CITY OF ALBUQUERQUE

Re: Taco Bell, 5215 Lomas Blvd. NE
Certificate of Occupancy – Transportation Development
Architect's Stamp dated 01-06-11 (J17-D014)
Certification dated 03-07-11

TRAFFIC CERTIFICATION

Re: Taco Bell, 5215 Lomas Blvd. NE, Traffic Circulation Layout
Architect's Stamp dated 12-24-10 (J17-D014)

SHEET NAME
SITE PLAN
SHEET NUMBER
SD-1.1

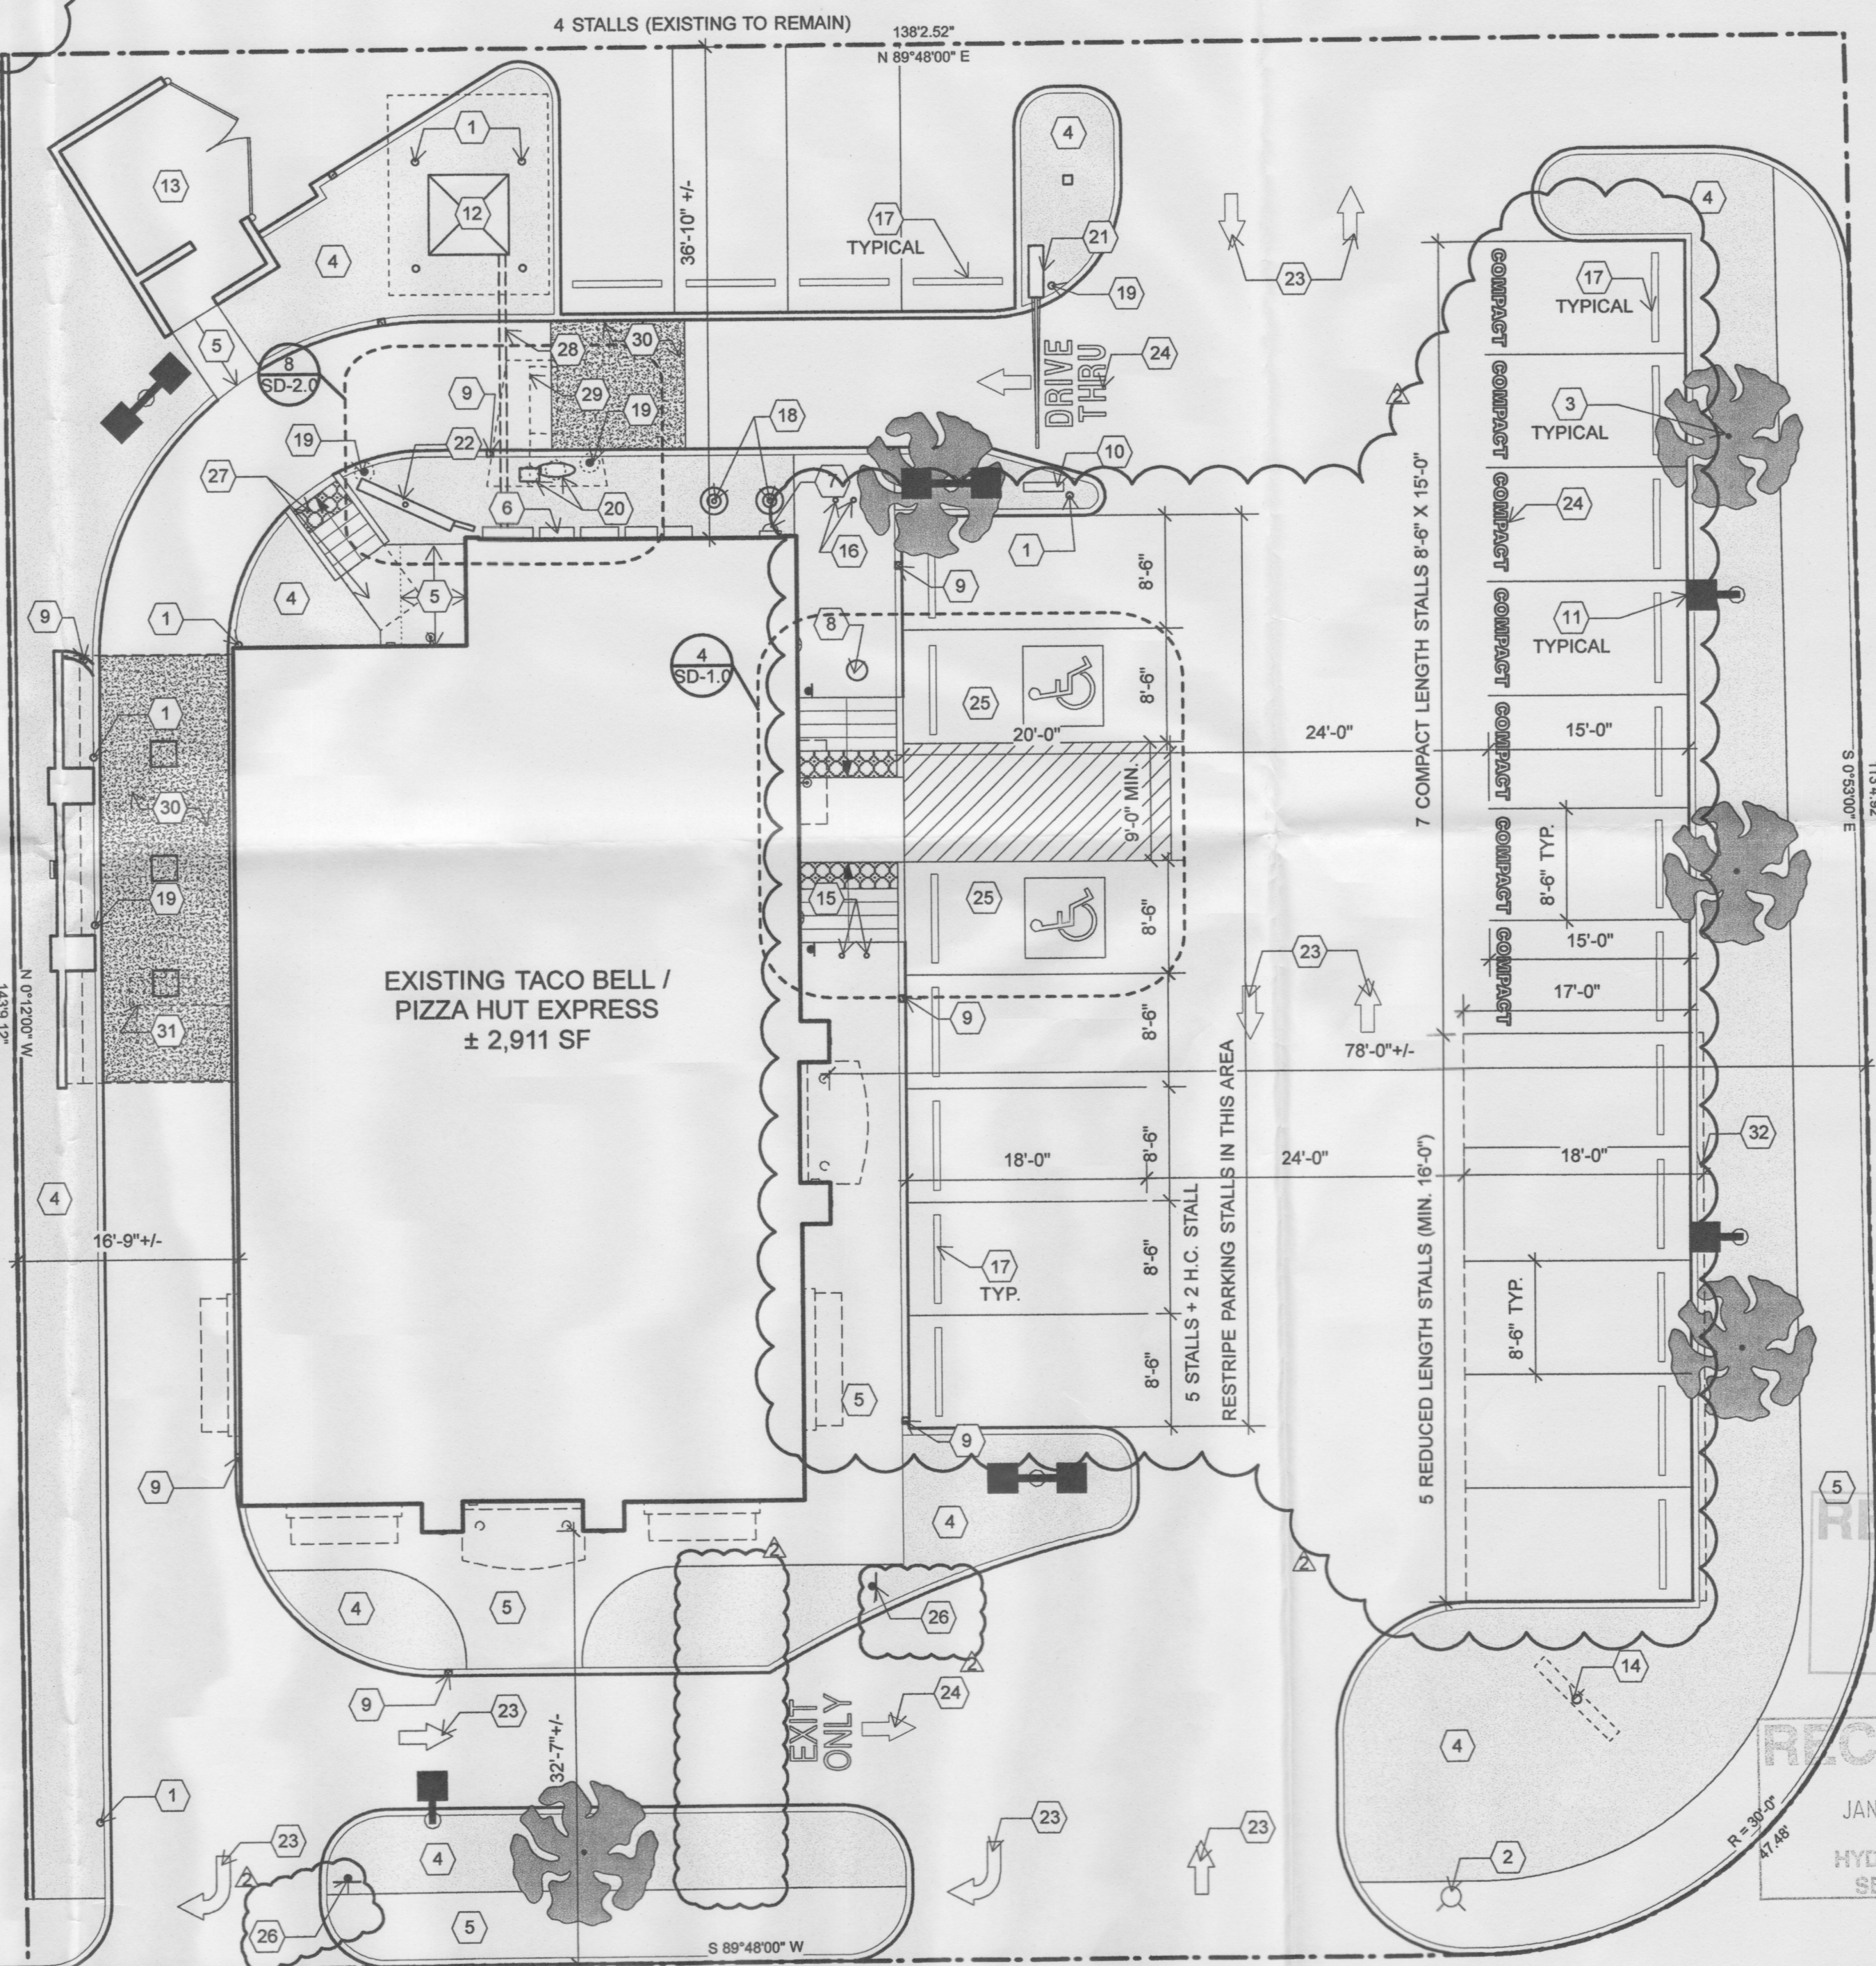
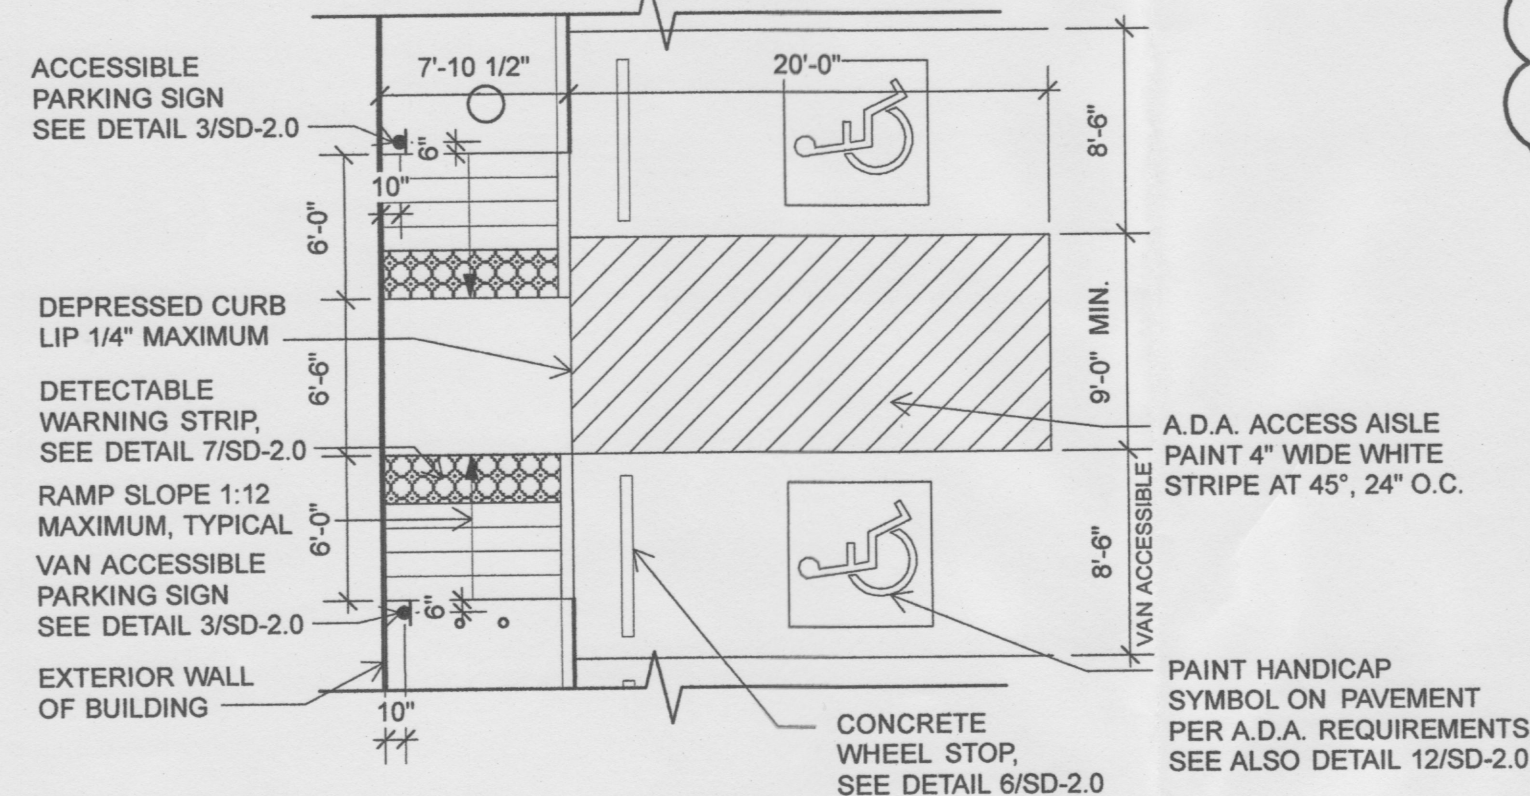
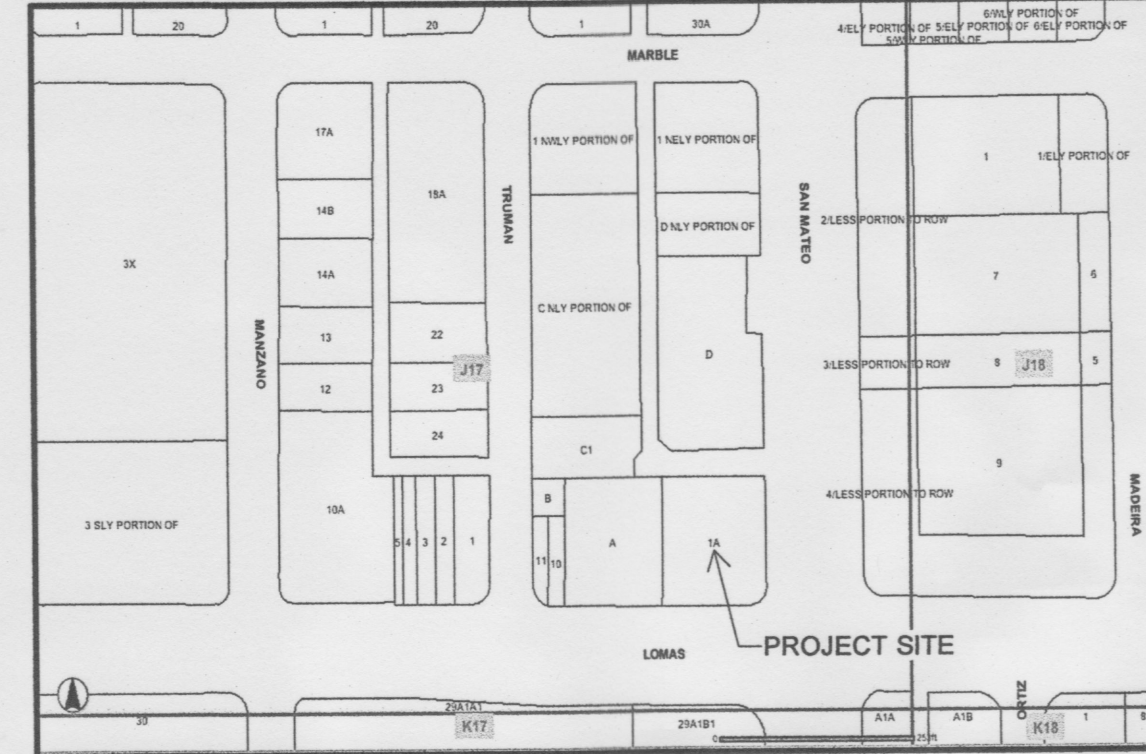
1. The sidewalk connection from Lomas Blvd. onto site will not work because: Grades appears to be very steep (need 5% max. for ADA access), conflict with existing ramp on Lomas, conflict with guy wire and possible power pole; sidewalk pathway must be 6 ft. minimum in width.
2. You'll need to provide 'Do not enter' signs (R5-1) at end of drive thru aisle fronting parking area and Lomas Blvd.
3. The parking stalls: Must meet minimum length (L) requirements (L=18 feet) and be designate compact (L=15 feet, label compact on stalls) where applicable; the proposed wheel ramp will need railing behind it and path must be 6 ft. wide with ¼" lip not ½" lip; must designate van accessible for one of the ADA stalls.
4. Provide vicinity map (zone atlas map).
